Our Ref: S11/0018

16 December 2011

**Re: State Significant Development
Shoalhaven Cancer Care Centre (Cnr Scenic Drive and North St, Nowra)**

Figure 3: Proposed SCCC layout

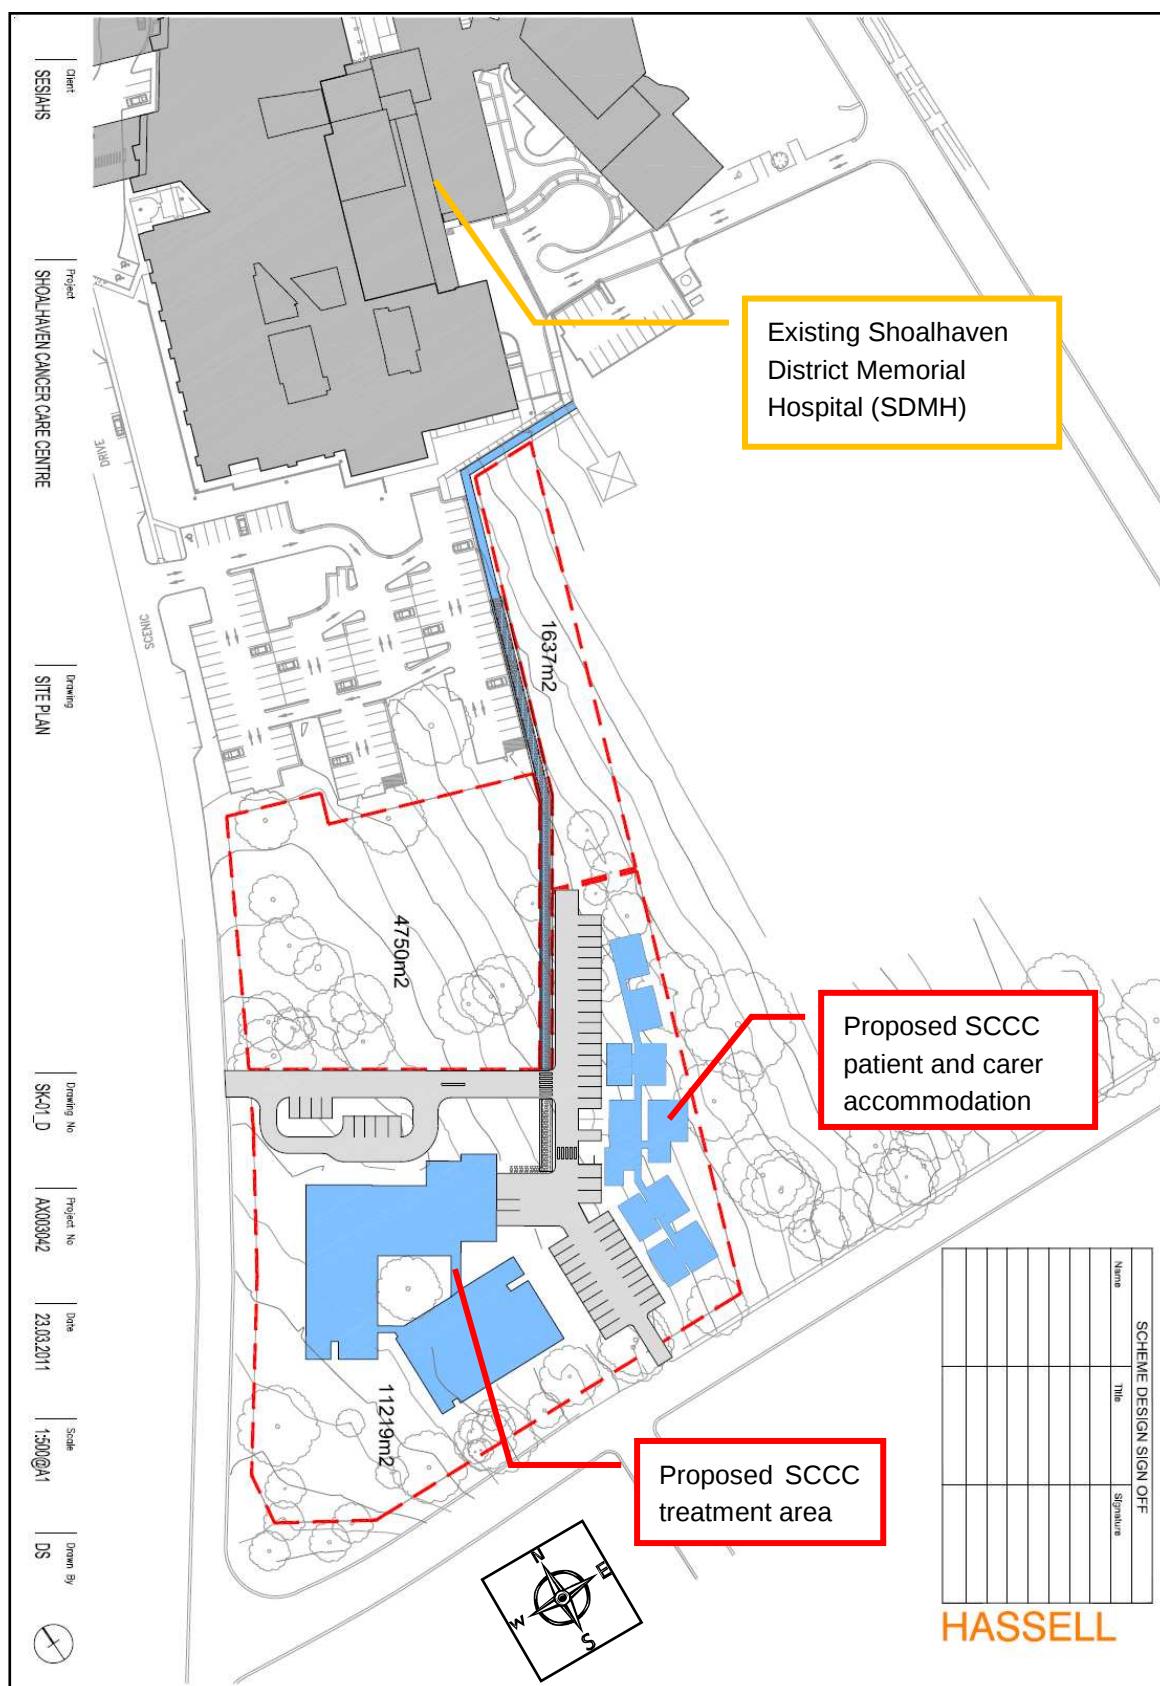
5. The proposed new buildings associated with the “*proposed SCC treatment area*” as identified on drawing number SK-01_D dated 23/03/2011 (Hassell) shall comply with section 5 (BAL 12.5) Australian Standard AS3959-2009 "Construction of buildings in bush fire-prone areas" and section A3.7 Addendum Appendix 3 of "*Planning for Bush Fire Protection*" 2006.

Note: No construction standard is proposed for the proposed *SCCC patient and carer accommodation* building identified on drawing number SK-01_D dated 23/03/2011(Hassell).
